CITY OF PORTLAND, MAINE
HISTORIC PRESERVATION COMMITTEE

61-C-13
October 17, 2000

Re: 309 Spring Street: Certificate of Appropriateness for modifications to a previously approved porch addition.

PLAN EXISTING CONDITIONS REAR PORCH

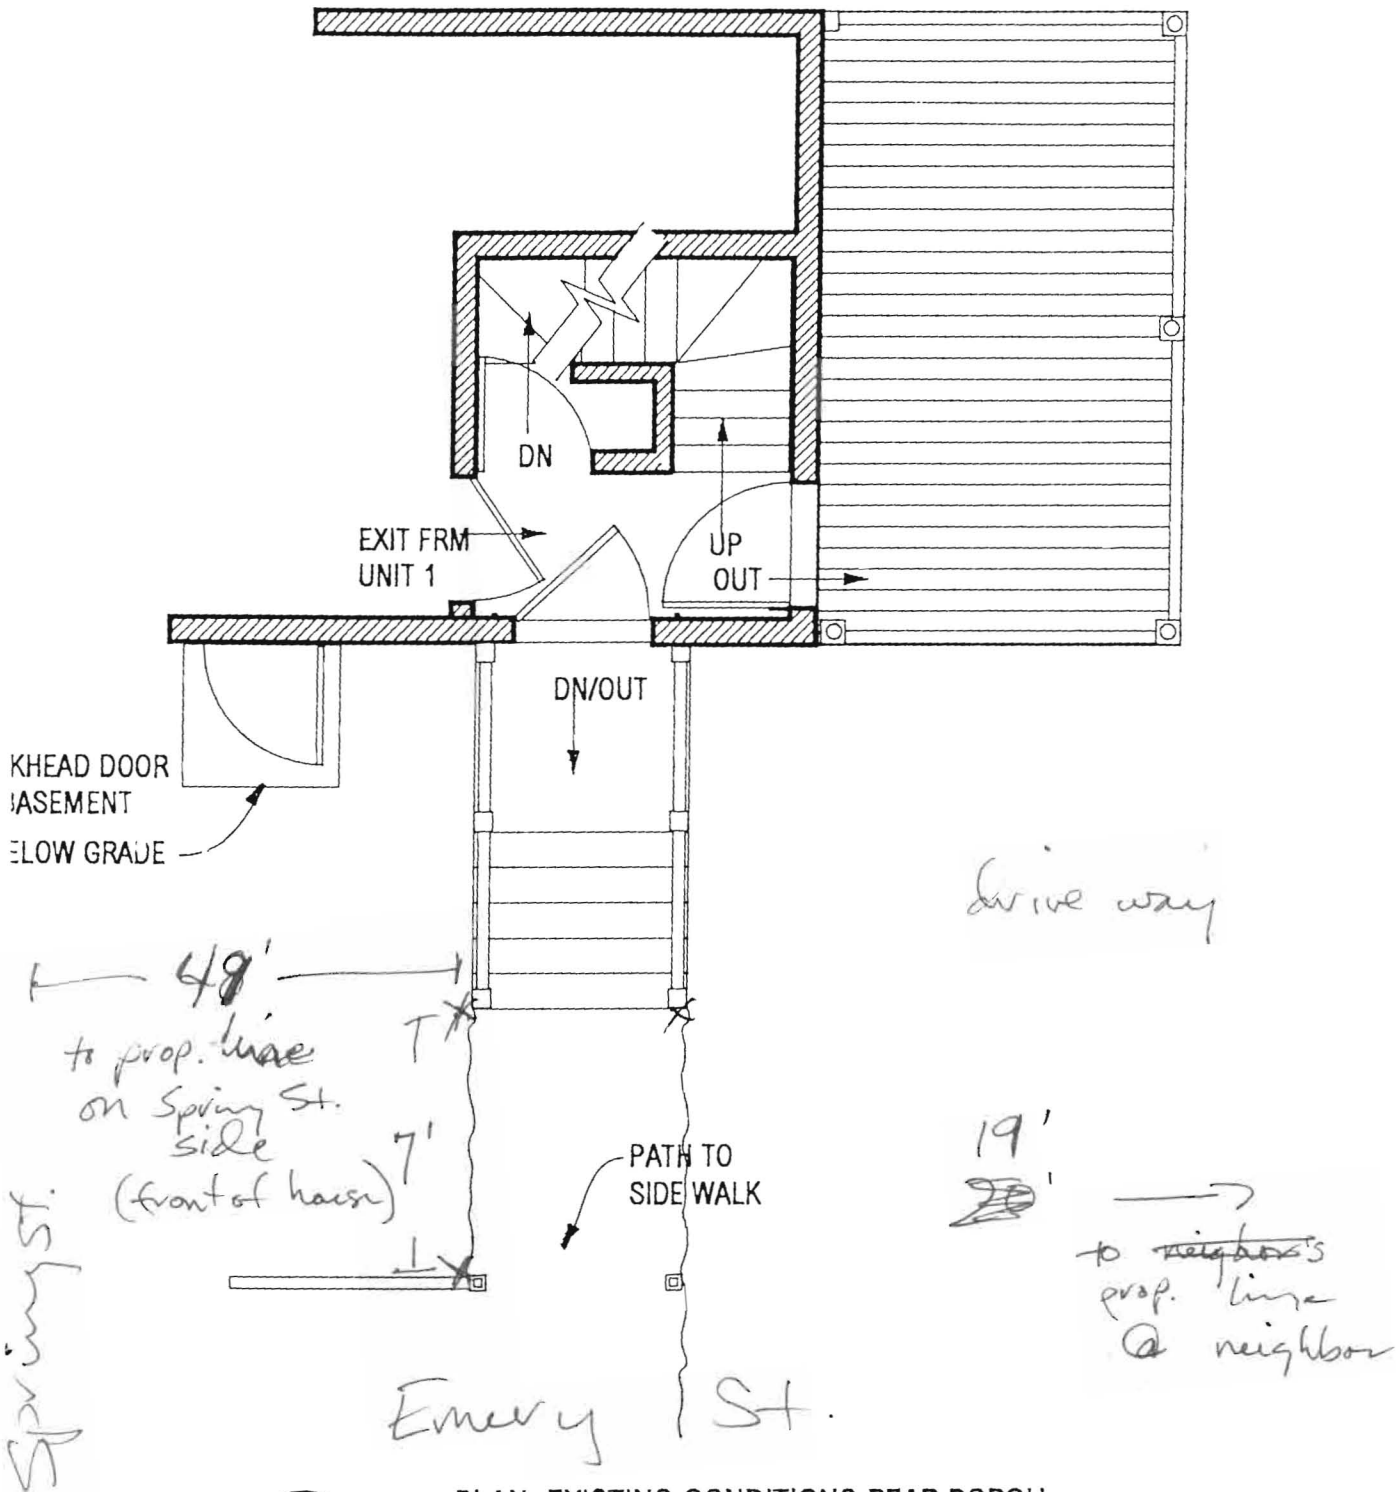
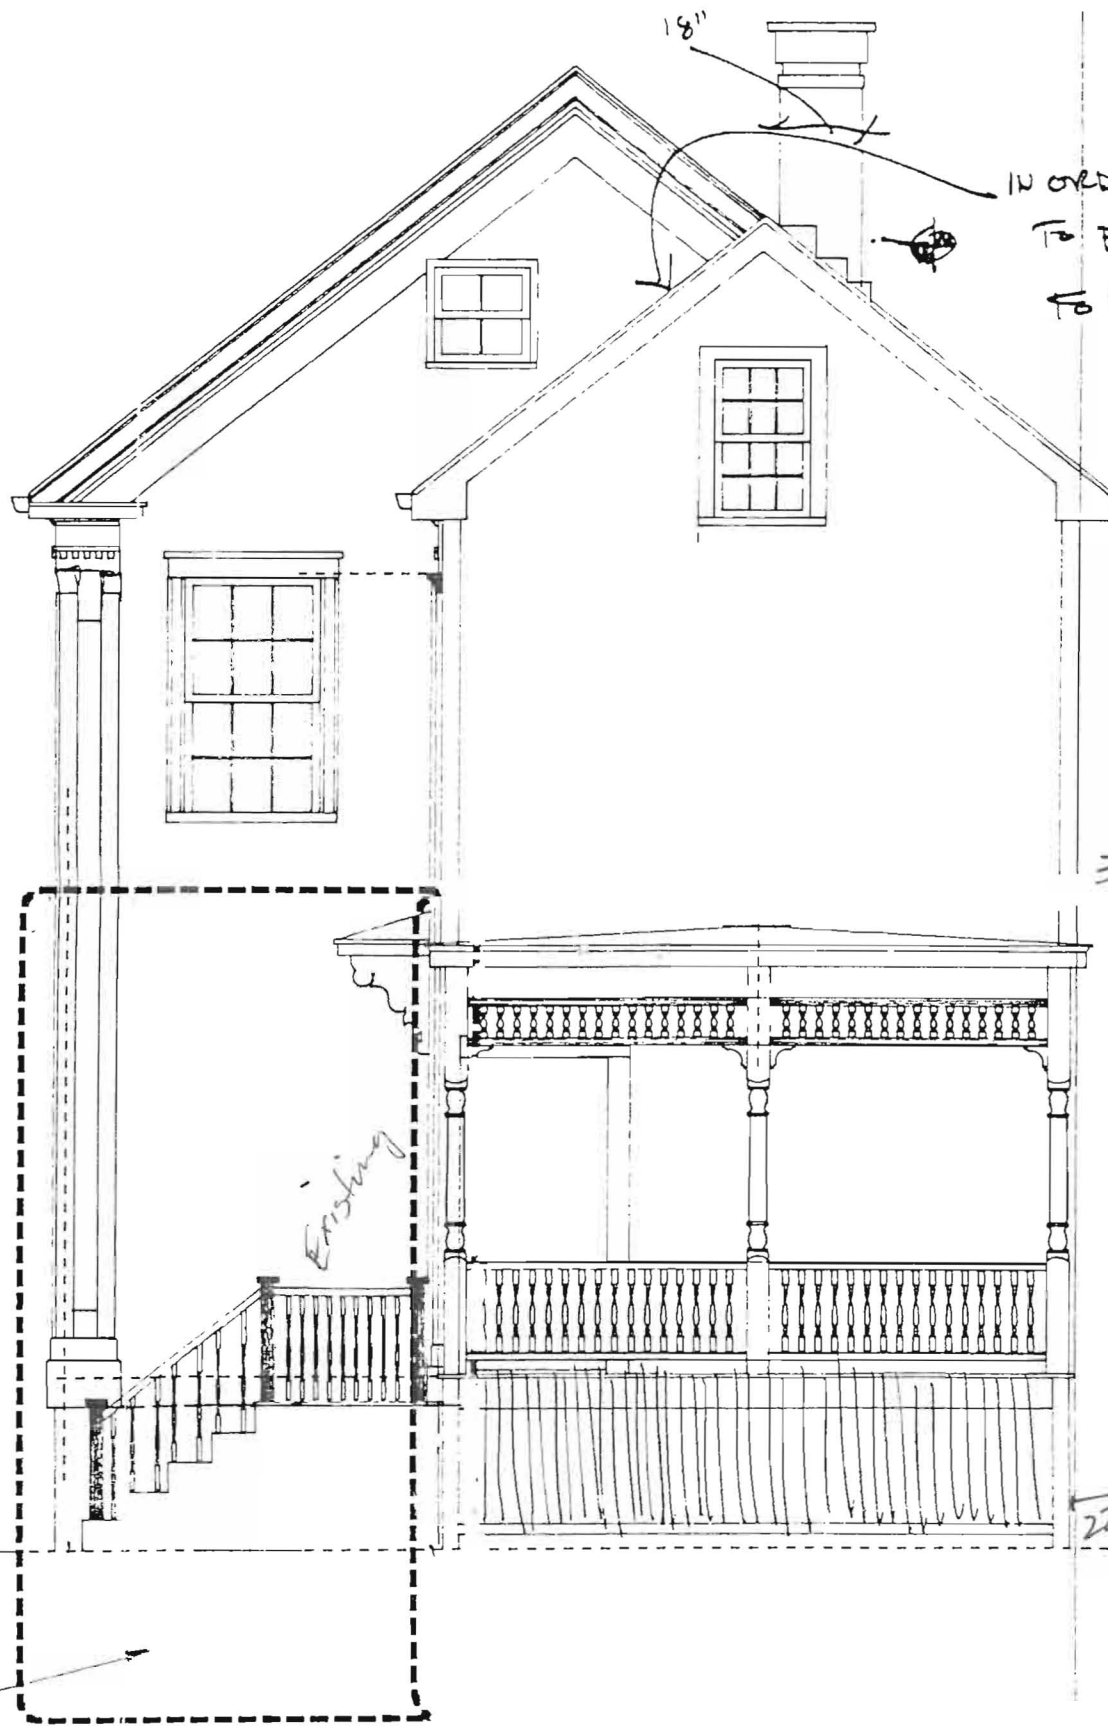
- i. That the posts supporting the second story deck be substituted with a chamfered square posts to be comprised of a 4"x4" post wrapped with 3/4" trim stock;
- ii. That a framing section be provided for historic preservation staff review and approval which reflects a Greek revival retro-fit of the existing second story deck/ roof cornice interface;
- iii. That spacing of railing balusters be adjusted to 2 3/8" clear;
- iv. That complete construction drawings be provided to Historic Preservation staff for review and approval; and,
- v. That the applicant apply to code enforcement for an exemption from building code railing height requirements for the top railing (siting Historic Preservation Standard #9 - compatibility of contemporary structures.)
